Re: Application Reference Number 2016/0623, 132 Park Grove, Barnsley, S70 1QG

We object to this application and request that it be refused for the following reasons:

LAYOUT AS PROPOSED

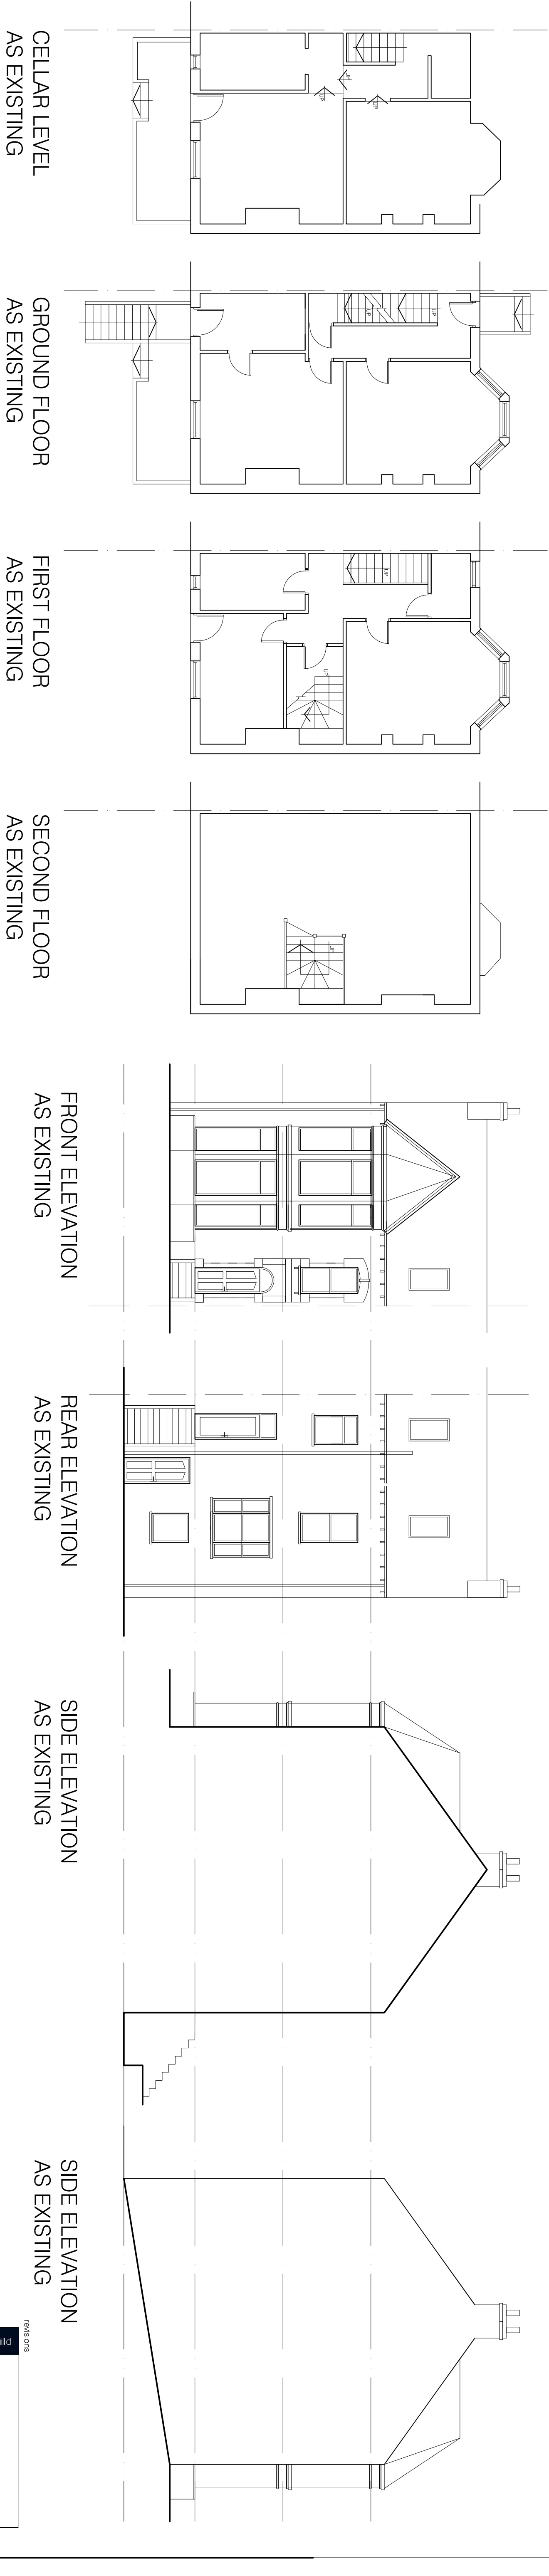
There is a discrepancy between the proposed and existing elevations provided by the applicant, suggesting that an existing doorway to the rear of the property would be sealed up, which also conflicts with the plans and Design & Access Statement. The Design & Access Statement refers to a staircase at the front of the house which is not shown on the drawings.

Dependent upon the Applicants actual intentions, the development may require the formation of a large excavation to the front of the dwelling. To reach the necessary formation level may require excavation to a significant depth. The excavation is adjacent the footpath of the highway which may be affected by the zone of influence.

Structural stability may also be further impaired by the presence of a boundary wall within the zone of influence. It is a commonplace occurrence for such walls to properties of this age to have shallow, informal foundations.

When corrected information is received from the Applicant, it is suggested that this should also include additional, detailed dimensioned sections for review and comment by interested consultees.

The Applicant's intention is to create a third floor extension by means of a flat-roofed structure over nearly all of the rear of the property. This appears to have been introduced with the sole intention of allowing the existing single attic room with limited head-height to be expanded and split into two so as to increase occupancy.

Although this is positioned to the rear of the house, due to its excessive size and the site orientation it would be a prominent feature of the street-scene. It is acknowledged that small dormer windows are present at the rear of some houses in the wider district; however these are invariably far more discrete, generally only visible from the rear, with owners favouring pitched roofs in order to reduce maintenance and improve aesthetic appeal.

The proposal is lacking in architectural merit and will be highly visible from both Charles Street and Park Grove.

The existing front garden is small, and the change in level between basement and front garden is such that a number of steps and a lower landing zone would be required to provide an access/egress stair which fully complies with Building Regulations. The creation of either a stair or light-well structure would take up an unacceptably large portion of the garden which would adversely detract from the aesthetic character of the street scene and also irreversibly impair the amenity value of the garden.
